CITY OF ALBUQUERQUE

Re: Lot 5A Richfield Park – Conceptual Grading & Drainage Plan (C17-D120)
aka: Lots 4 & 5, Richfield Park Subdiv. (No P.E. Stamp: <Plan dated 5/21/12>)

Based upon the information provided in your submittal received May 22, 2012, and our discussion this morning, the Conceptual Grading and Drainage Plan is acceptable, conditioned upon the following:

CONCEPTUAL GRADING AND
DRAINAGE PLAN

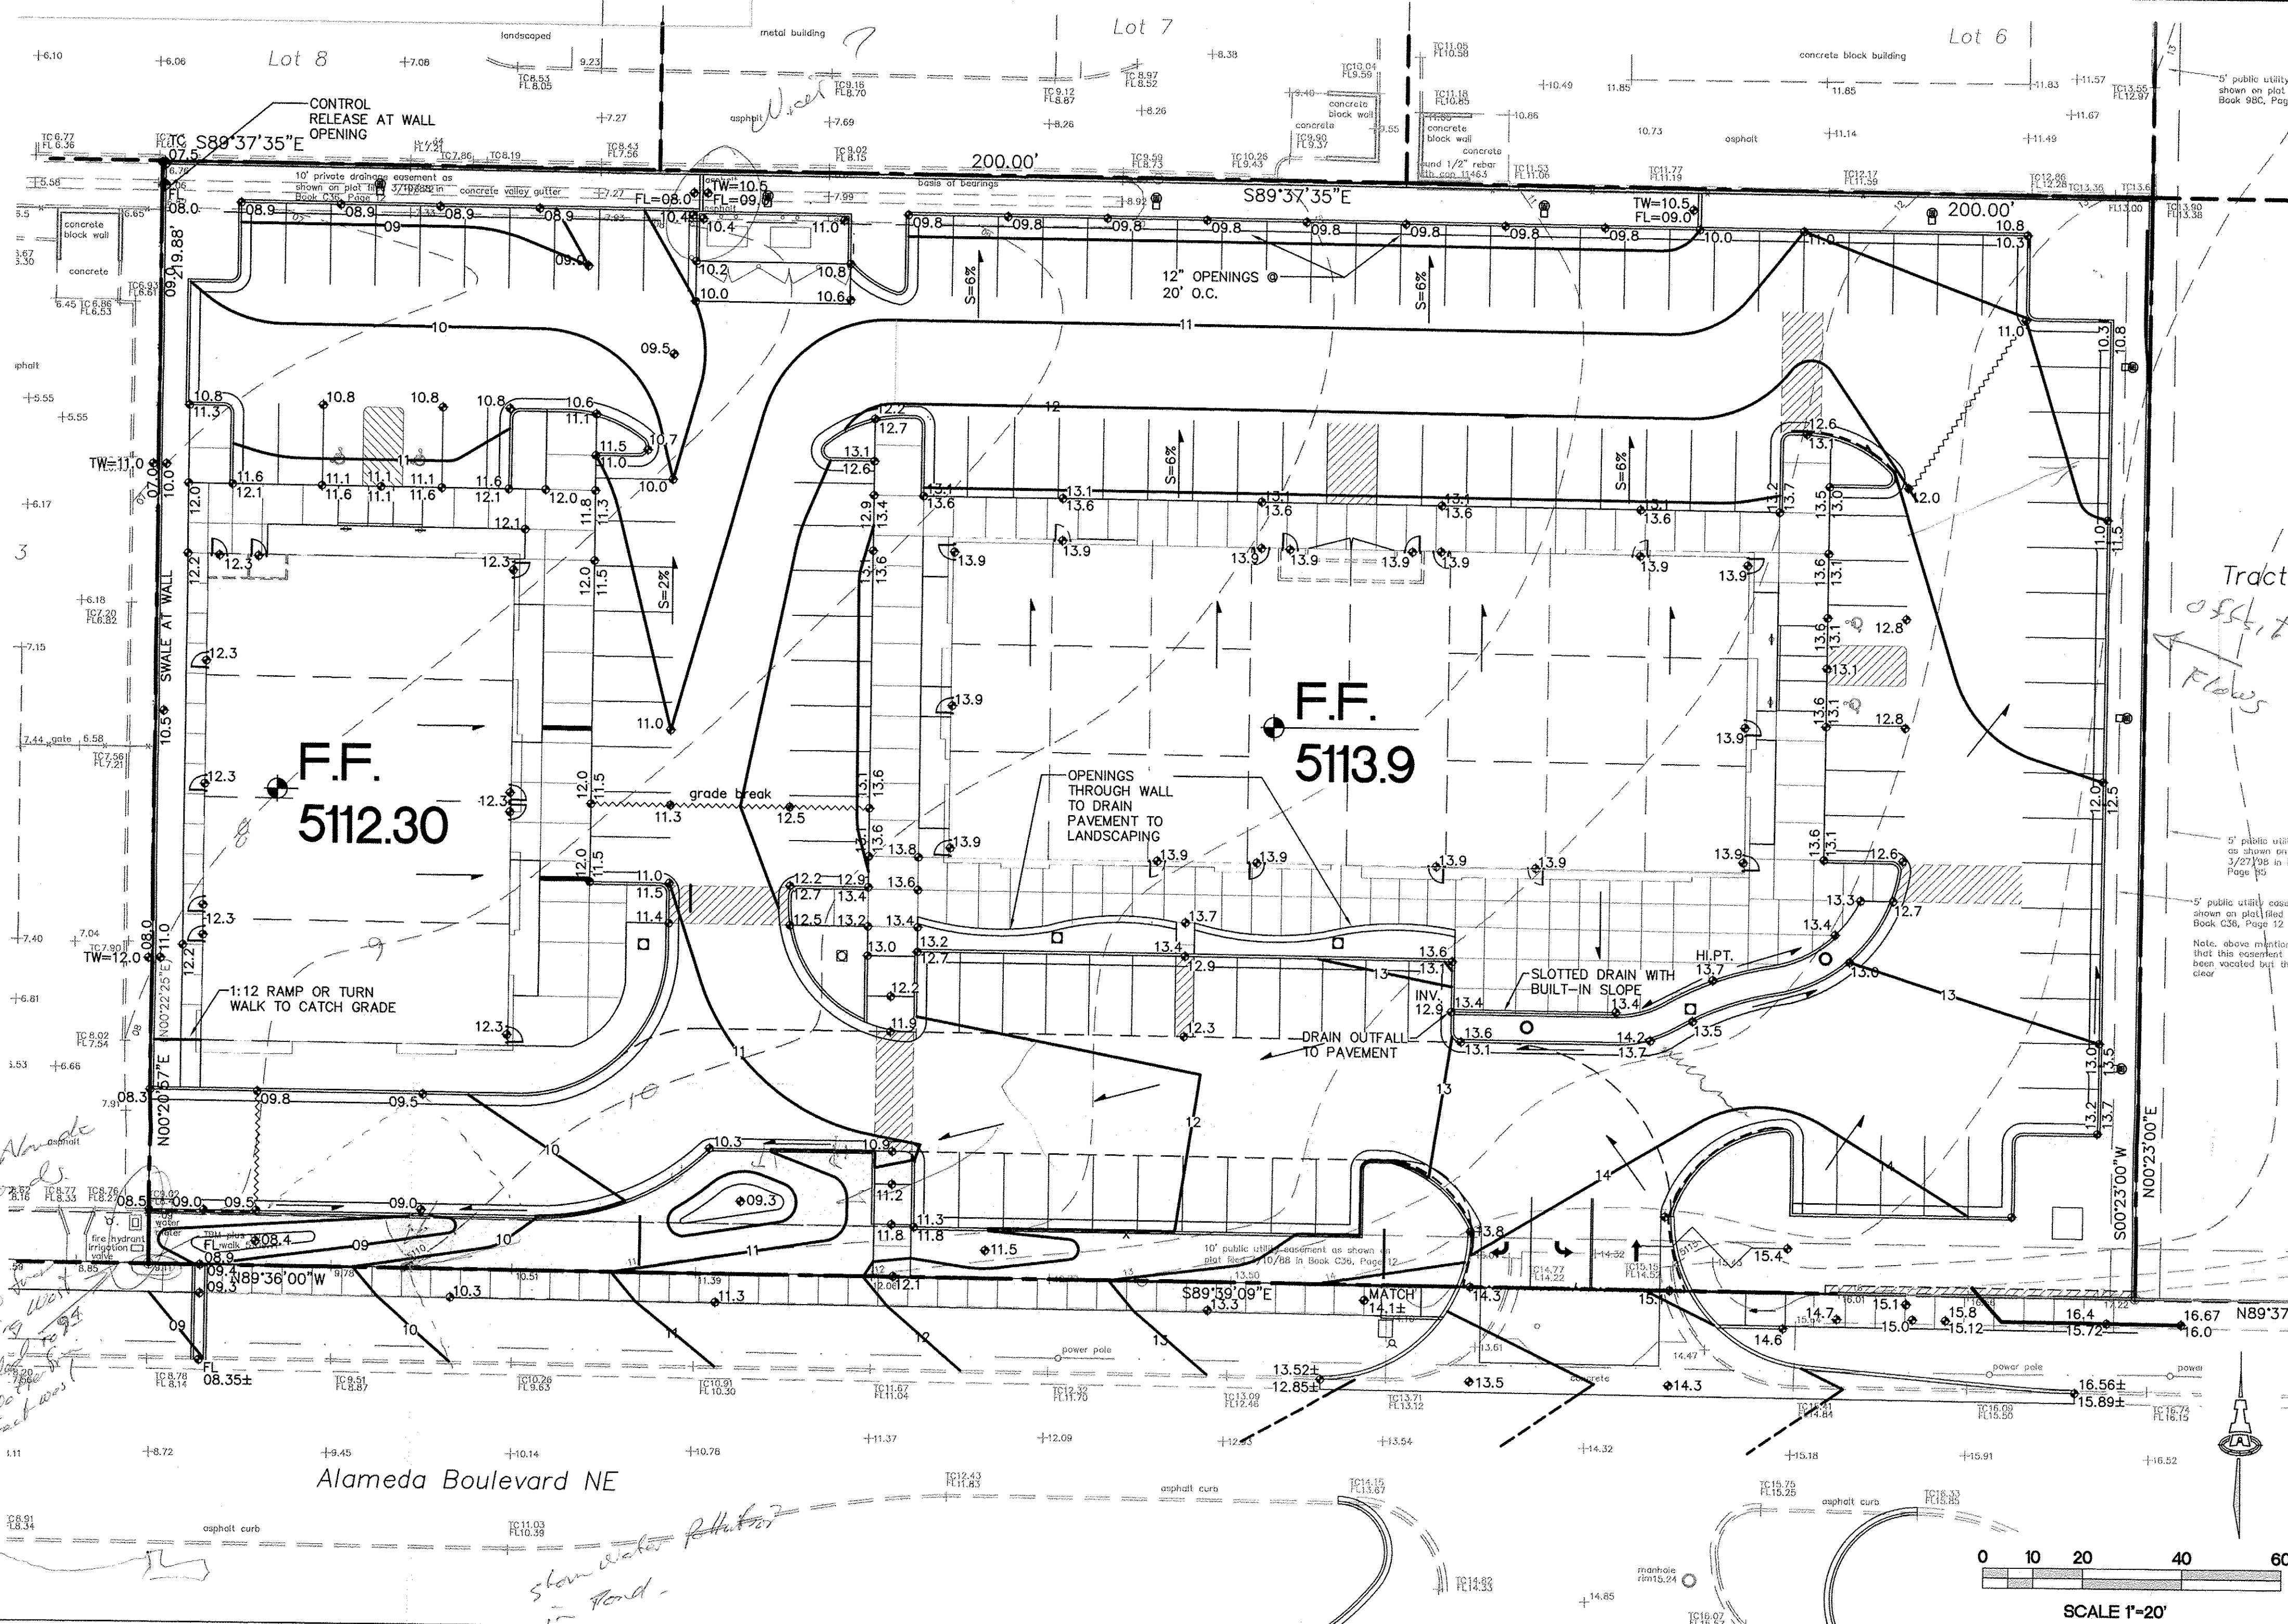
1. Offsite flows appear to be possible from the east. We have no record of development on Parcel C1-D to the east of this site. Provide documentation with photos and topography that offsite flows will not enter this site.

2. The concept of Basin 1 discharging to Alameda Blvd. will be allowed, but the peak discharge rate must be kept close to 2 cfs. Building Permit plans should provide details of how the flows are routed through the water harvesting basins in the southern landscaped areas, and what the peak discharge will be at the SW corner of the site. Provide sufficient detail to ensure that flows intended to leave the site through the sidewalk culvert do not overflow the sidewalk or west property line.

3. Provide more detail of how Basins 2 & 3 will be routed through the terraced ponds on the North and West boundaries, and weir or orifice calculations demonstrating the restriction of discharge to 2.11 cfs at the NW corner of the site.
